Re: Objection to MP08_0244 MOD 1 Modification Request for Mixed Used Development at 23-37 Lindfield Avenue and 11 Havilah Lane, Lindfield

1 SHADOW DIAGRAM - 21stDEC_9AM
5003 SCALE1 : 650

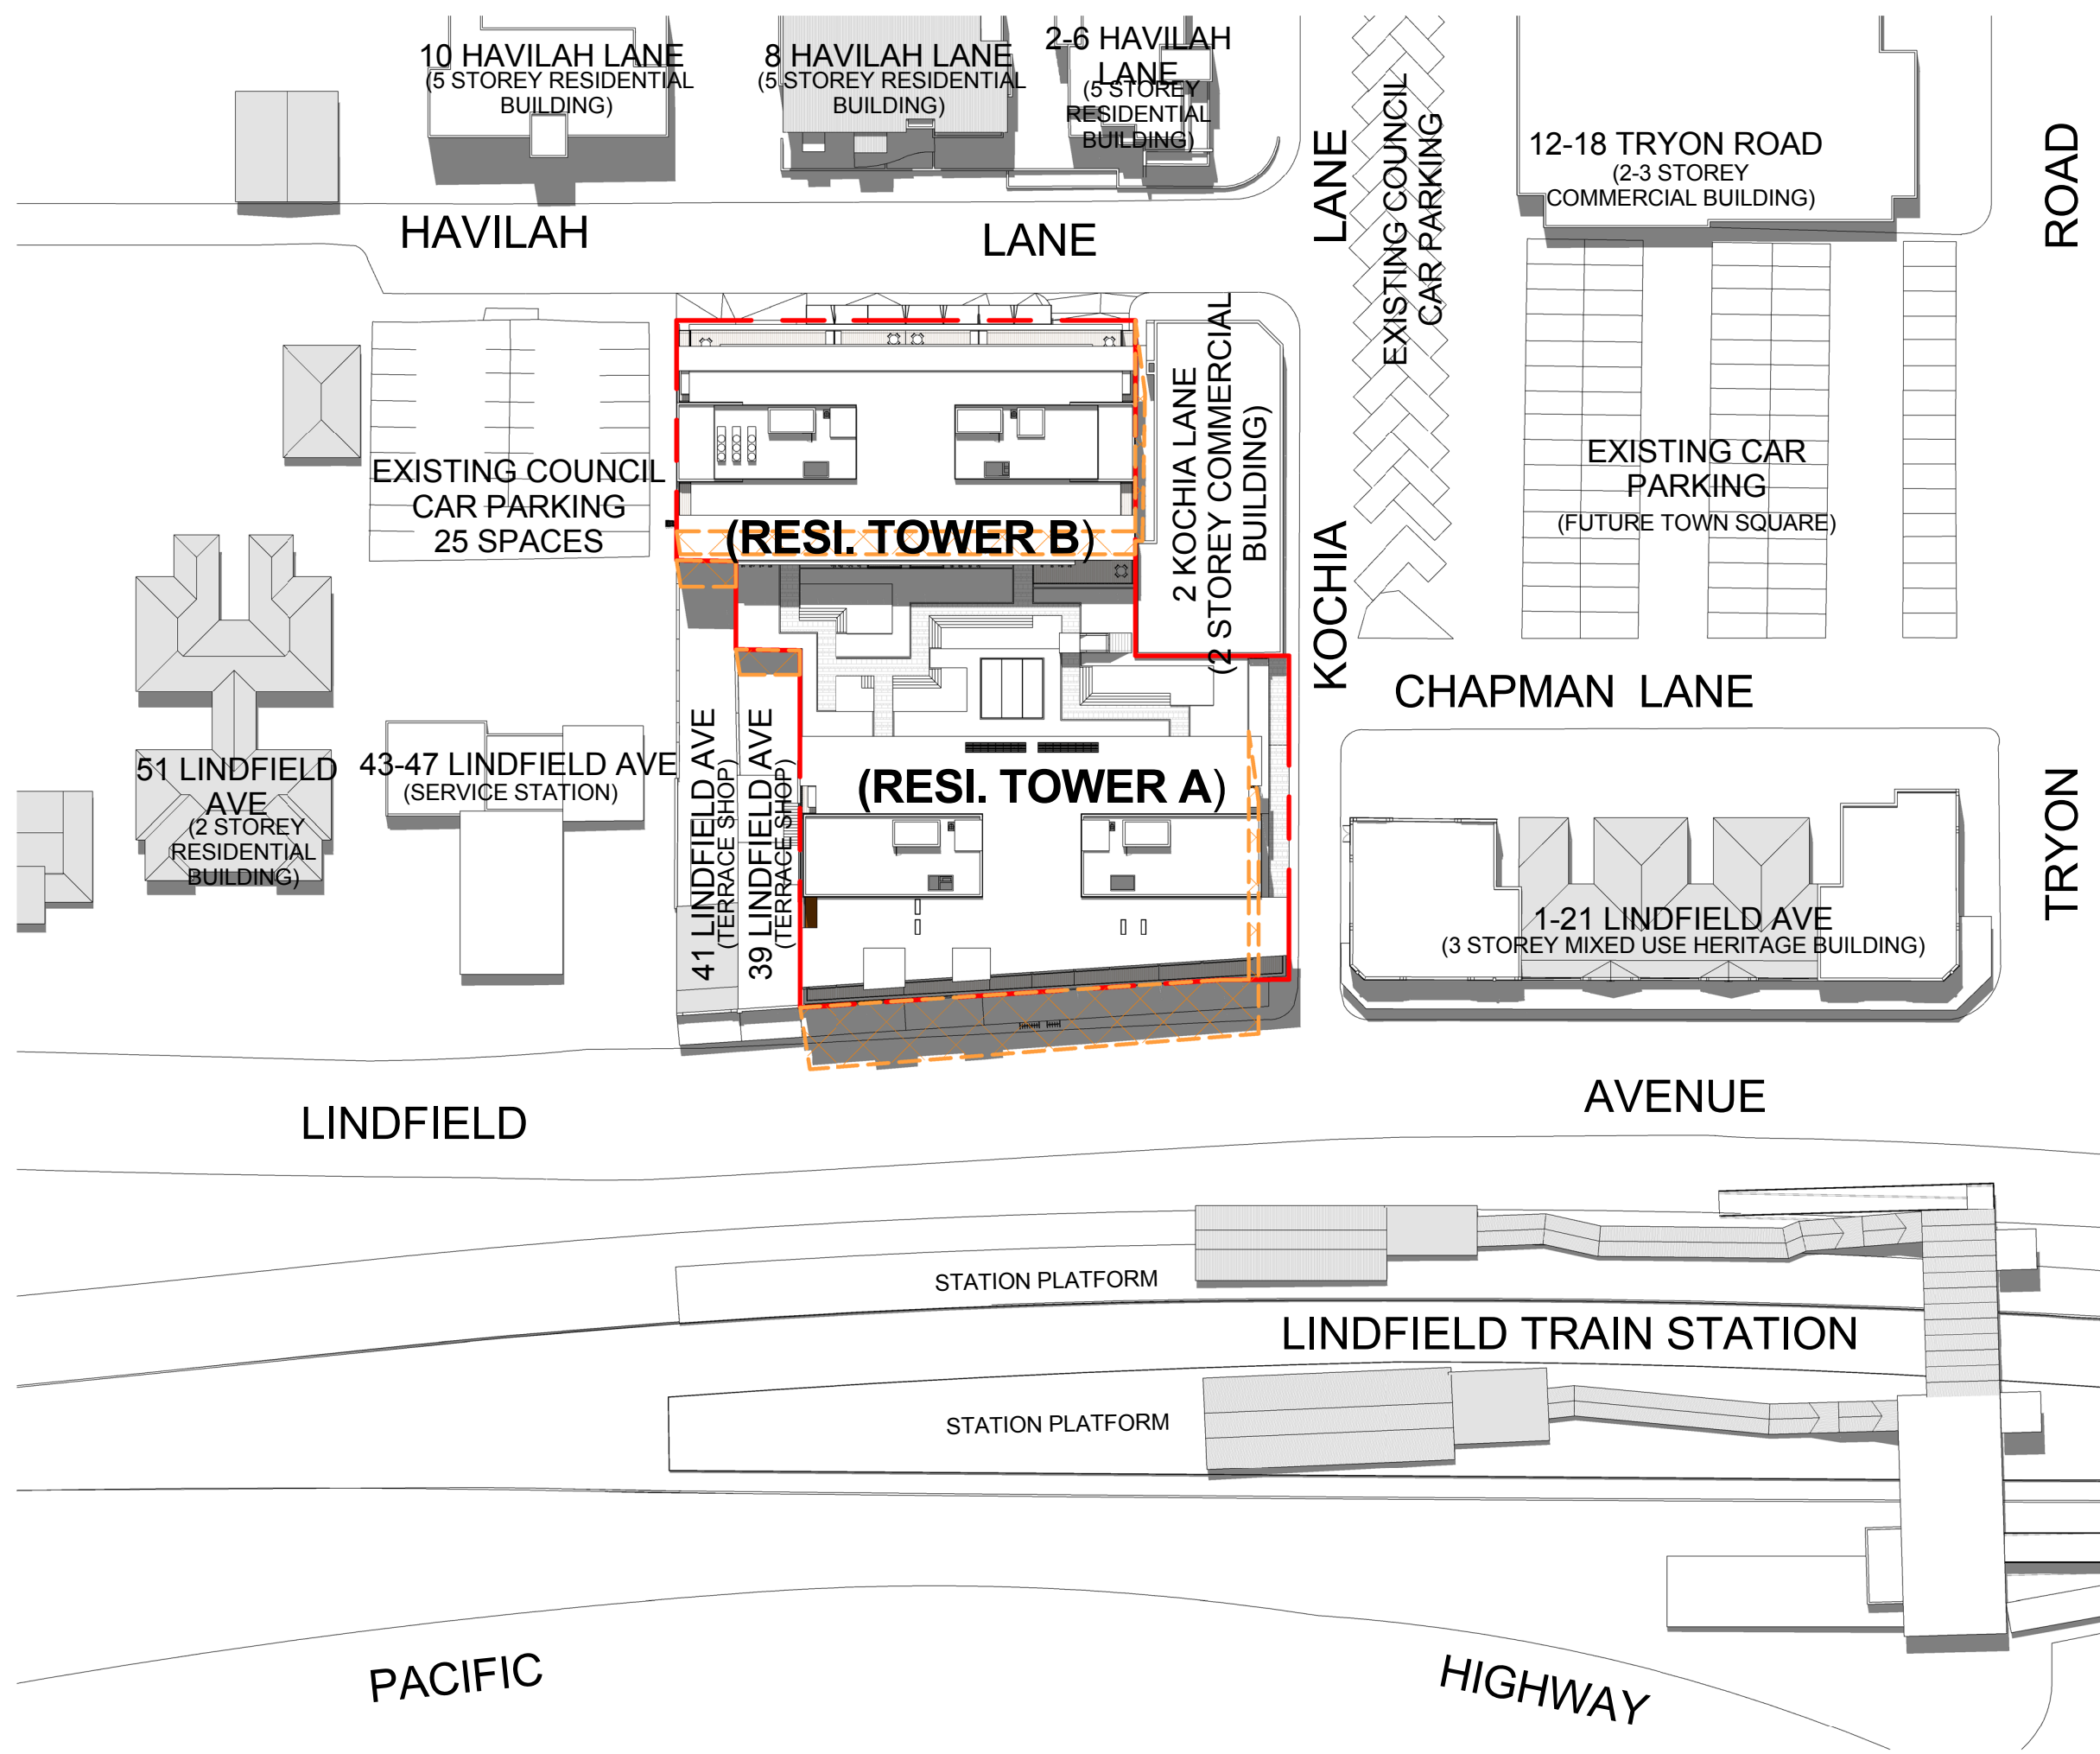
- The additional storeys create new adverse shadowing: a) for residents in the Havilah Lane apartments, particularly after 3pm b) for the popular outdoor café and central Lindfield hub area at 12 Tryon Road in afternoons, particularly in winter and c) for all commuters on the city bound Lindfield rail platform, instead of 50% of the year as approved, it will now be in shadow in the mornings 75% of the year
